## KITTITAS COUNTY COMMUNITY DEVELOPMENT SERVICES

**Subject:** Wies WFC Tower Pre-Application Meeting, CDS Planning Notes

**Proposal:** Pre-application meeting for a proposed 197' WFC tower, associated service equipment, and access on parcel #952139, approximately 17.74 acres, located at 520 Jenkins Drive in Cle Elum, WA.

**SUBJECT:** Pre-Application Meeting PM-25-00009, CDS Building Notes.

TUMBLING RIDGE PRELIMINARY PLAT

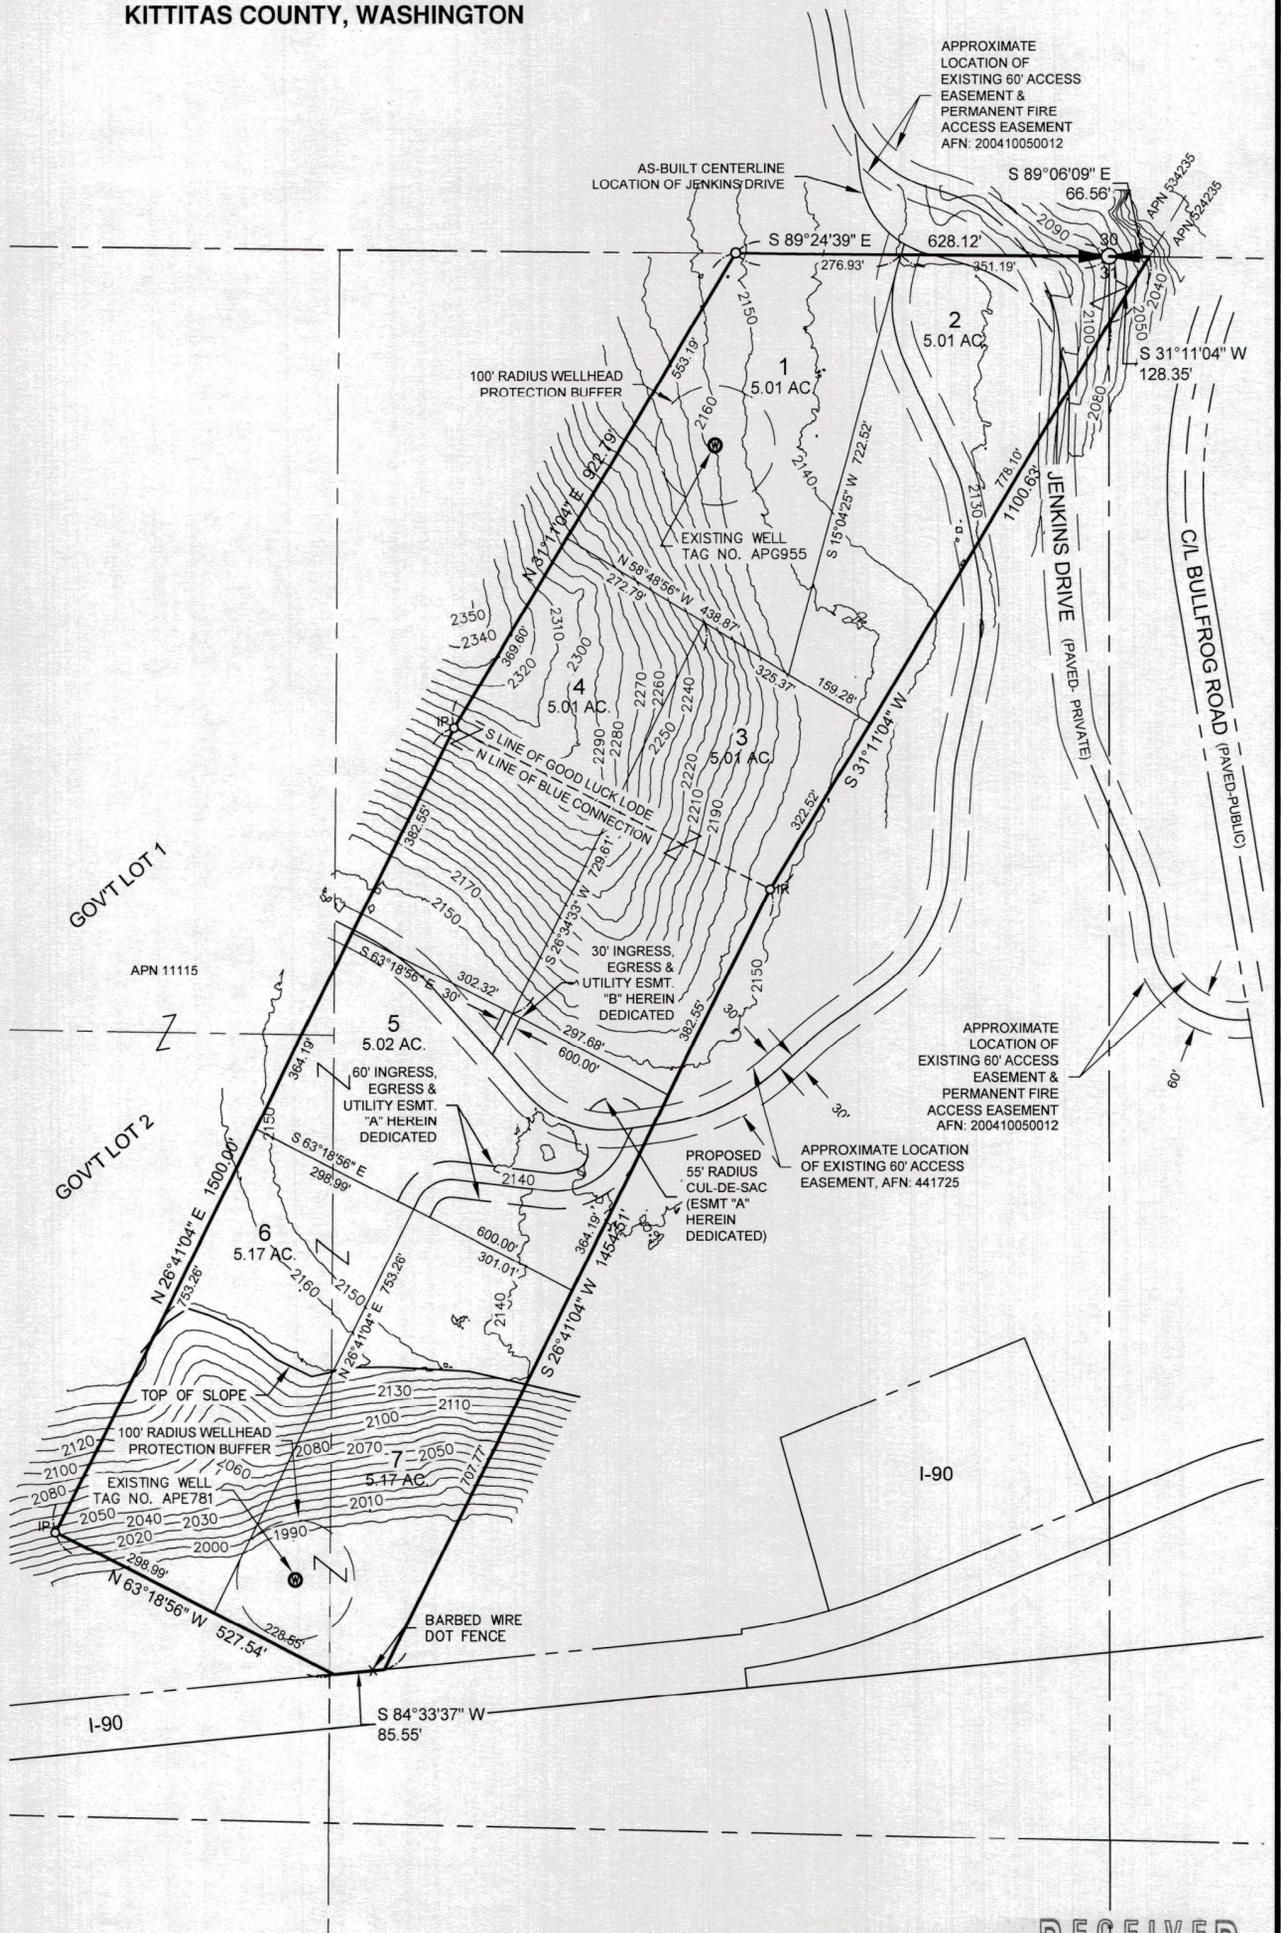
The tower's proposed location is sufficient for condition (3). If the distance to any property line is reduced from what was proposed at the time of the pre-application meeting, a zoning variance application will be required.

When the Final Plat for LP-23-00002 is applied for, a note shall be recorded on the final mylar drawings stating the location of the tower and its distances to all property lines.

Fire apparatus access is required for this application. The roadways and maneuvering areas as indicated in the application do not adequately provide required fire apparatus access. Provide fire apparatus access roads with an unobstructed width of not less than 20 feet, an unobstructed vertical clearance of not less than 13.5 feet, with an all-weather driving surface and capable of supporting the imposed loads of fire apparatus. Access roads shall extend to within 150 feet of all portions of the facility and all portions of the exterior walls of the first story of the building.

Approved fire apparatus turnarounds are required for this project. The indicated provisions for turning around fire apparatus are not adequate. Provide a turnaround meeting the requirements of the International Fire Code Appendix D.
